From: Martin Hill <Martin.Hill@arun.gov.uk>
Sent: 09 October 2020 20:31
To: Planning.Responses <Planning.Responses@arun.gov.uk>
Subject: RE: Planning Consultation on: FP/180/20/PD

Comments from Private Sector Housing:

Application No:	FP/180/20/PD
Registered:	5th October 2020
Site Address:	23A Felpham Road Felpham PO22 7DA
Grid Reference:	494840 99605
Description of Works:	Notification of Prior Approval under Schedule 2, Part 3, Class M of the Town & Country (General Permitted Development (England) Order (as amended) for the change of use from shop (A1) to residential (C3).

Drg. no. 2017/02x Sept. 2020
O'NEILL ARCHITECTURAL SERVICES
Tel: [01243] 531333

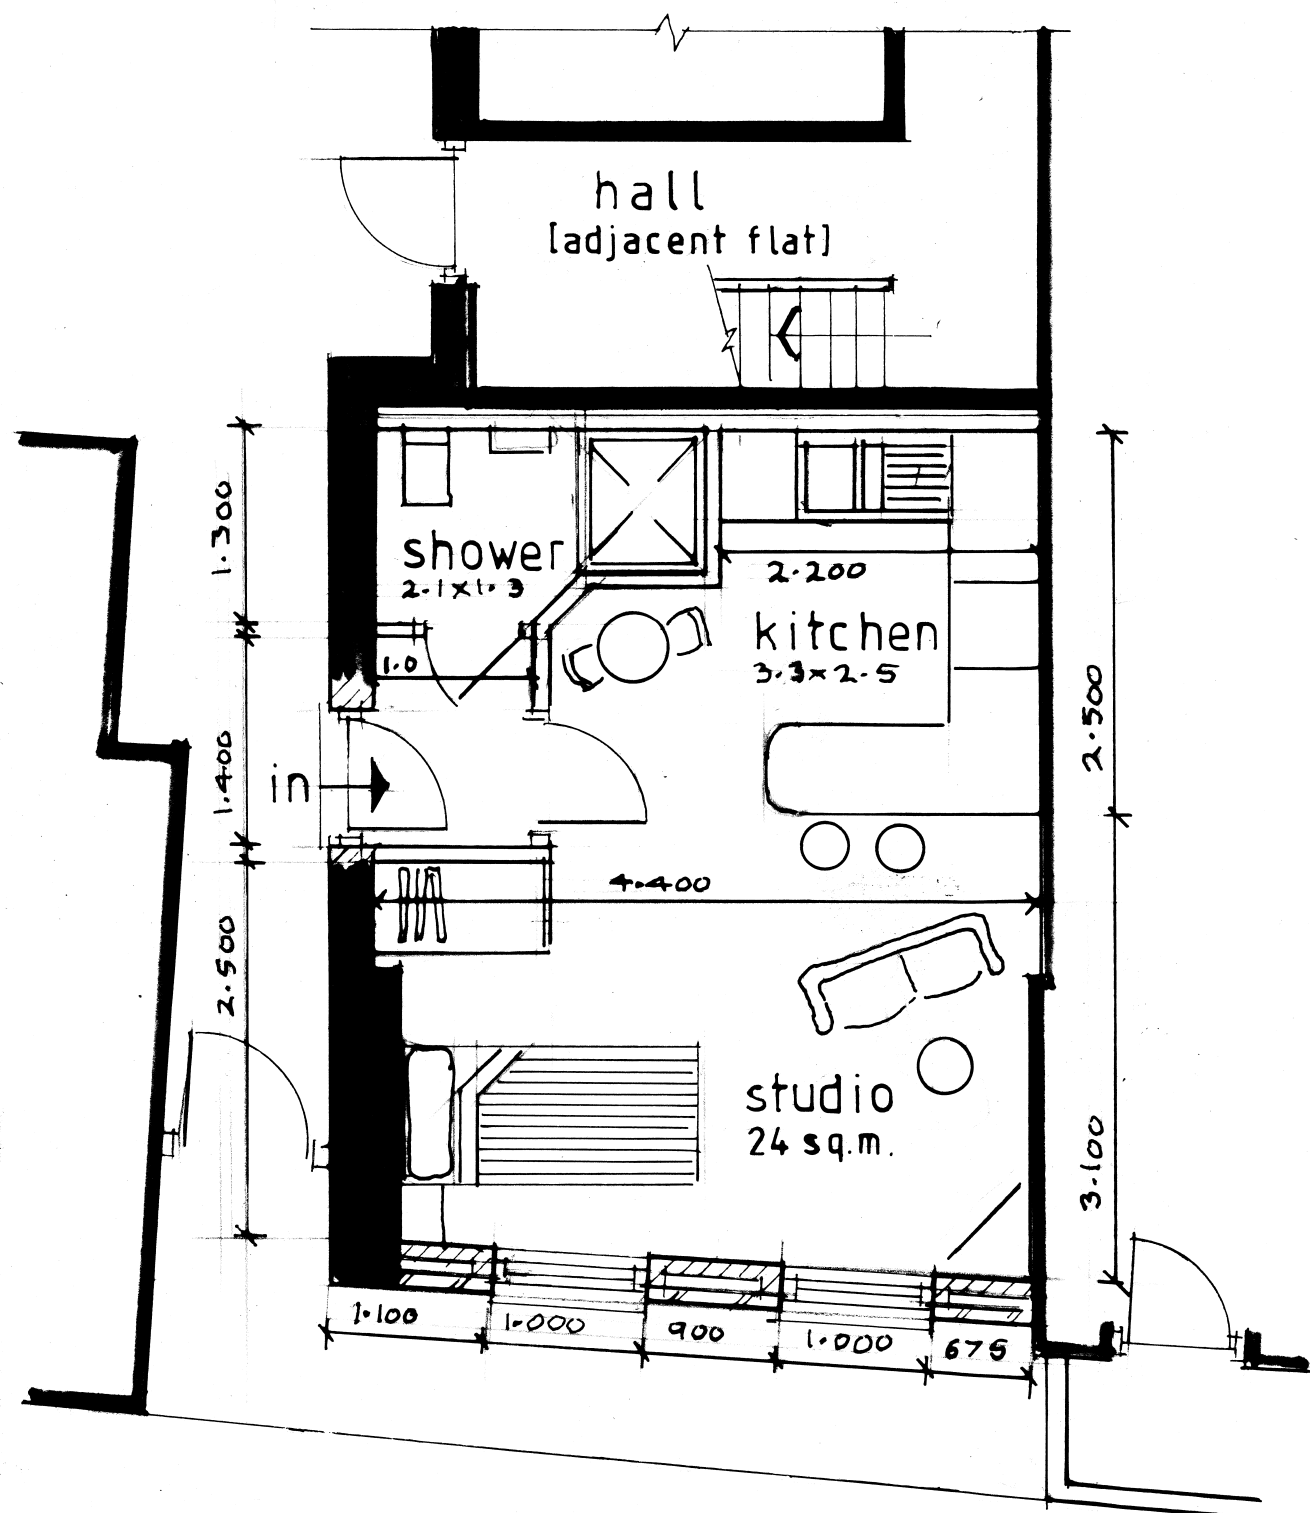
- Appropriate fire precaution facilities and equipment must be provided of such type, number and location as are considered necessary. Guidance on fire safety is contained in the LACORS guidance document – “Housing – Fire Safety, Guidance on fire safety precautions for certain types of existing housing”
- There should be adequate fire separation between the proposed ground floor studio and the residential unit above. If 1 hour fire separation cannot be guaranteed between the ground and first floor, a mixed system of both interlinked and non-interlinked fire alarm systems must be installed, as follows:
- Grade D LD3 fire alarm and detection system (non-interlinked):
 - o Mains wired smoke alarm with integral battery back-up located in the studio flat.

Grade D LD2 fire alarm and detection system (interlinked):

- Interlinked smoke alarms with integral battery back up in any shared internal escape route within the entire property.
- Interlinked heat alarms with integral battery back-up to be located in the entrance lobby/hall of each flat in the entire property. The applicant is advised to seek the advice of a Fire Risk Assessor to determine all appropriate fire safety precautions for the property as a whole. It would appear to be advisable to locate the heat alarm of the ground floor studio flat in the vicinity of the kitchen, rather than in the entrance lobby in view of the layout of the studio flat.

- The floor to ceiling height must be at least 2.1 metres from floor to ceiling over at least 50% of the floor area when measured at a height of 1.5metres from the floor and provide sufficient useable space.

Room size must be:

Single occupancy: 13m²

Double occupancy: 15m²

- The bathroom and kitchen areas should have adequate mechanical ventilation.
- All habitable rooms must have an opening window, equivalent to 1/20th of the floor area, to the outside air to provide adequate ventilation. French or patio doors that have no separate openable casements, or where there is no alternative openable casement within the room, are not considered acceptable in bedrooms.
